Subject: Project Mars Data Centre, Lane Cove West – Additional matters for submissions report

ATTACHMENT 1

Based on the Department's review of the information provided in the Environmental Impact Statement (EIS), the Department considers further information is required to clarify matters and address inconsistencies within the documentation. In this regard, the following information is required to be provided as part of your submissions report:

1 EAST ELEVATION
1 : 500

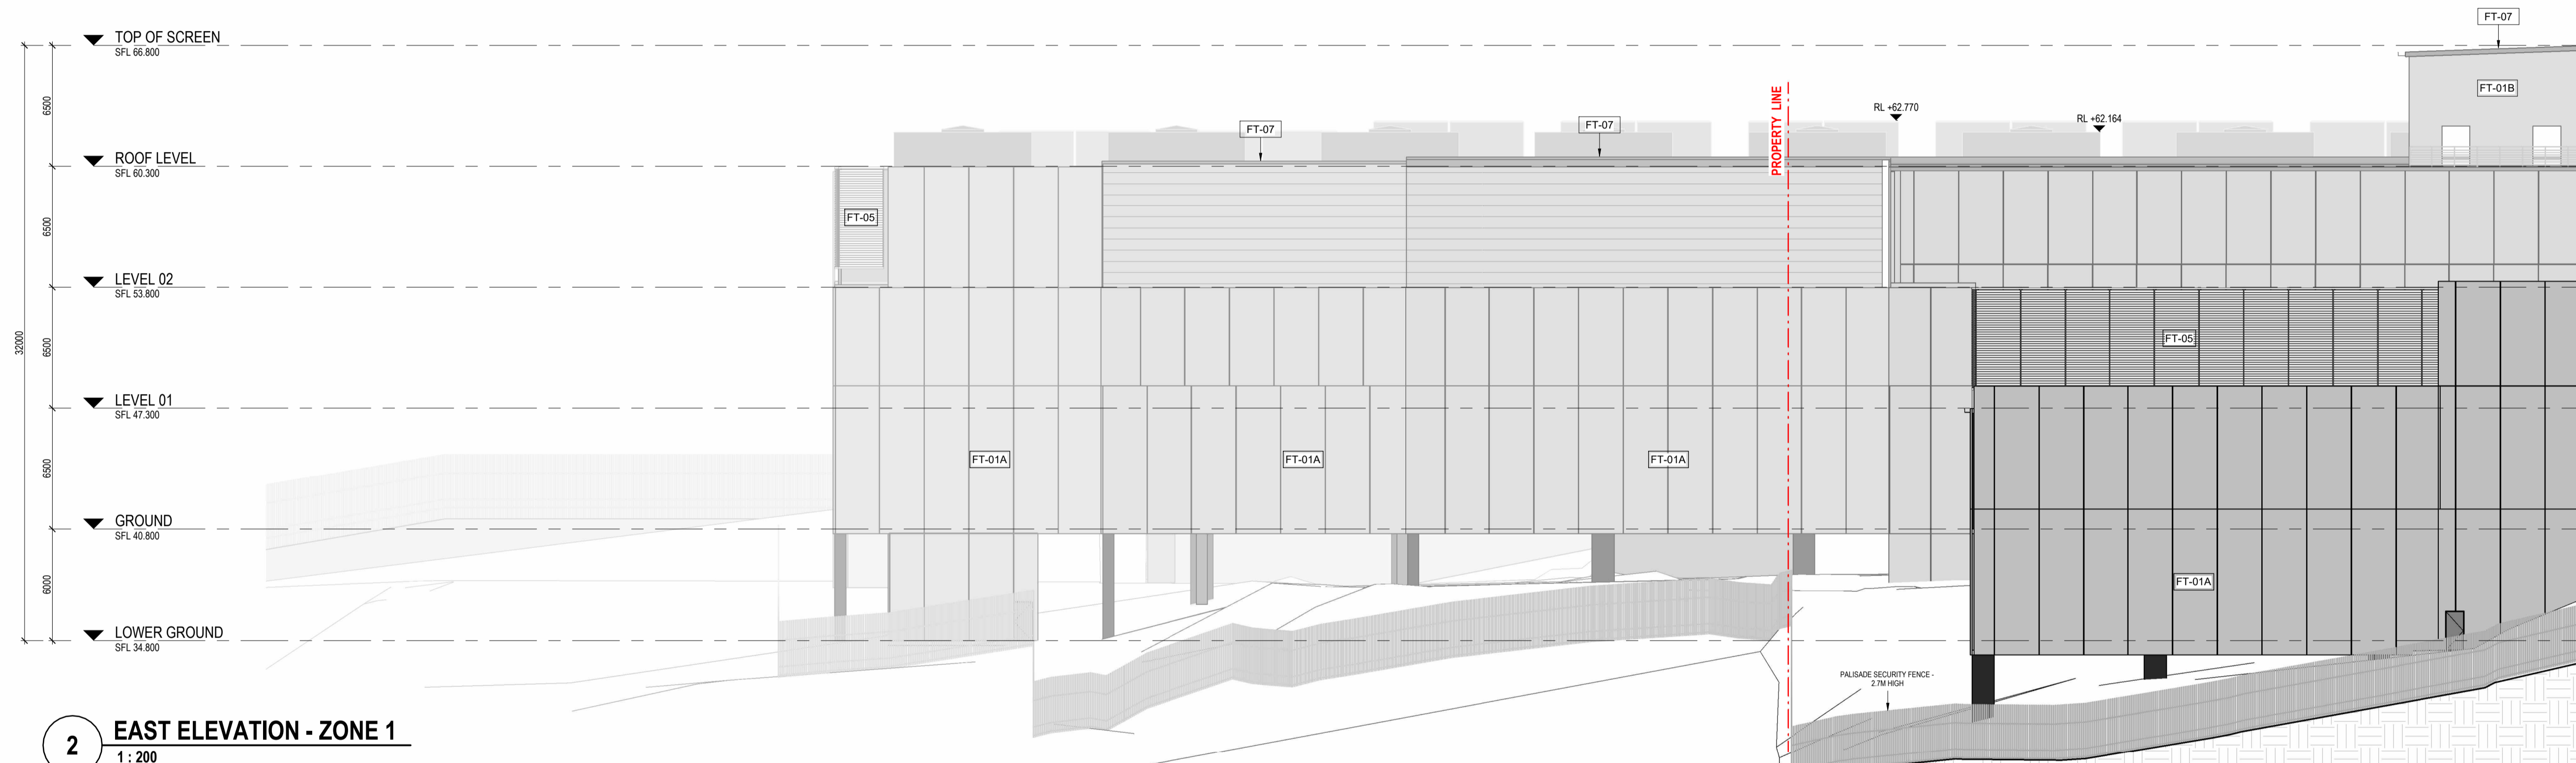
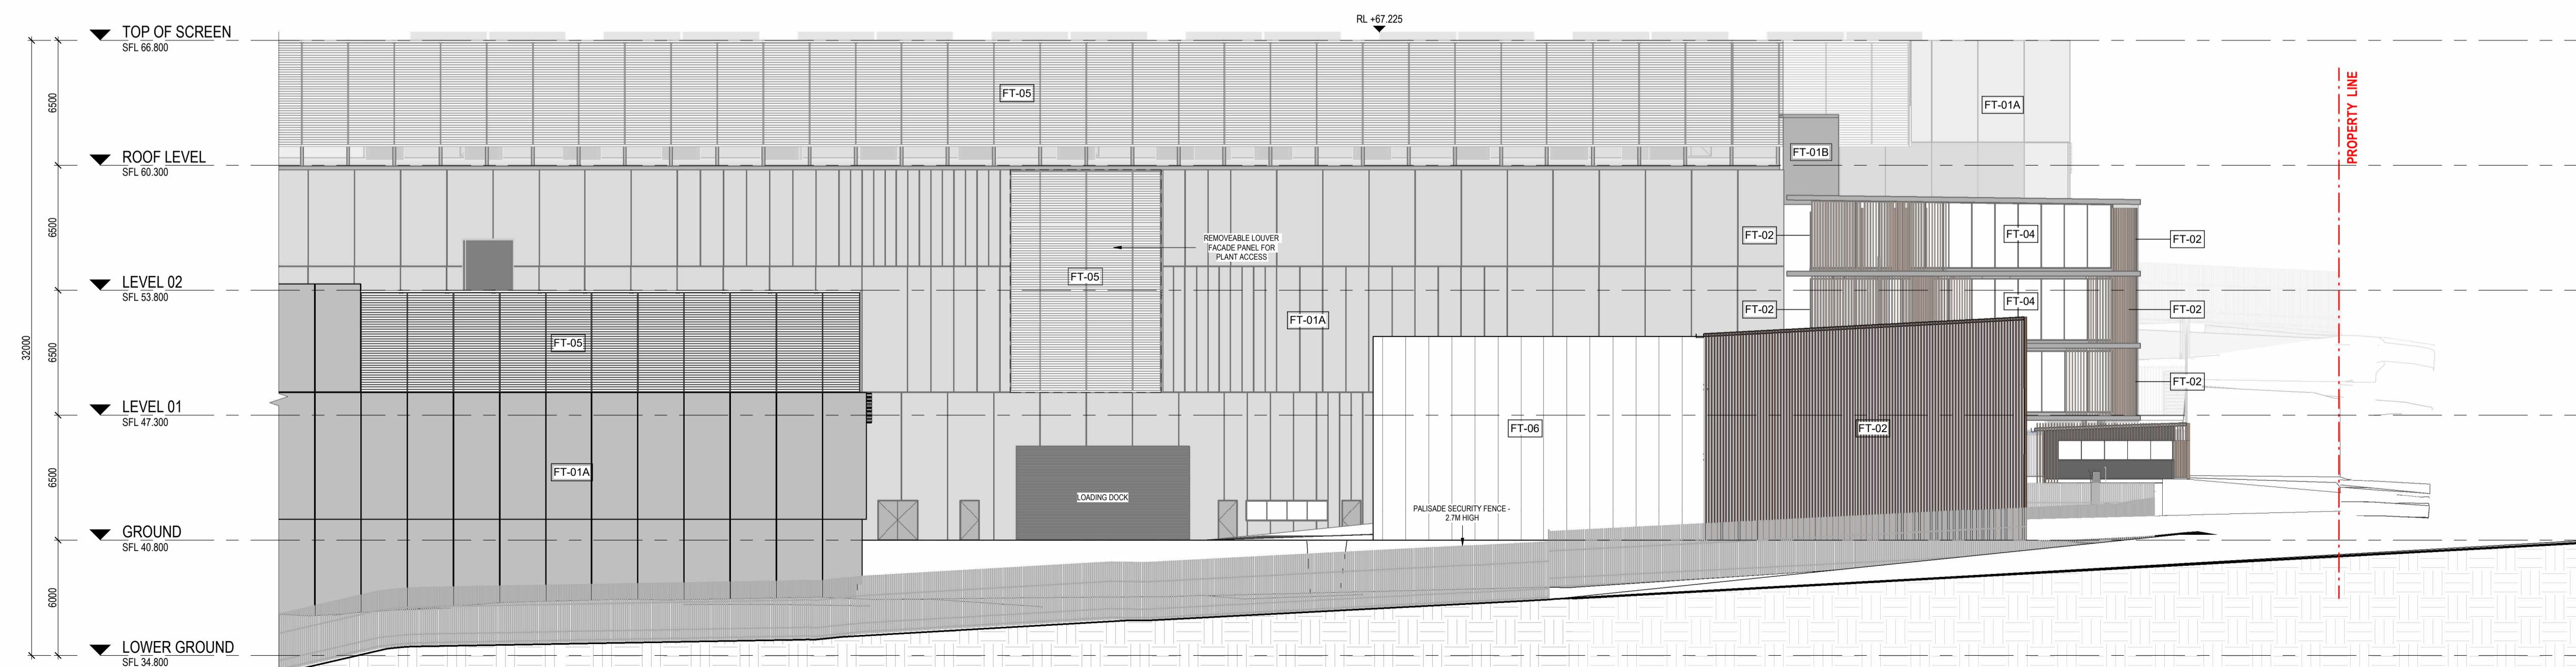
8. The Department acknowledges a number of public submissions have raised concerns in relation to the development's interface with the adjacent community nursery and nearby residences. Additionally, Lane Cove Council has also raised a number of concerns regarding the proposed Clause 4.6 variation to the 'Height of Buildings' control.

Given these concerns, strong consideration should be given to implementing additional design measures to the development's eastern façade, to help reduce the building's perceived bulk and scale and ensure there is no net loss to sunlight for those receivers to the east. In this regard, such measures could include additional façade treatments and/or building articulation or a reduction in building height and increased setbacks.
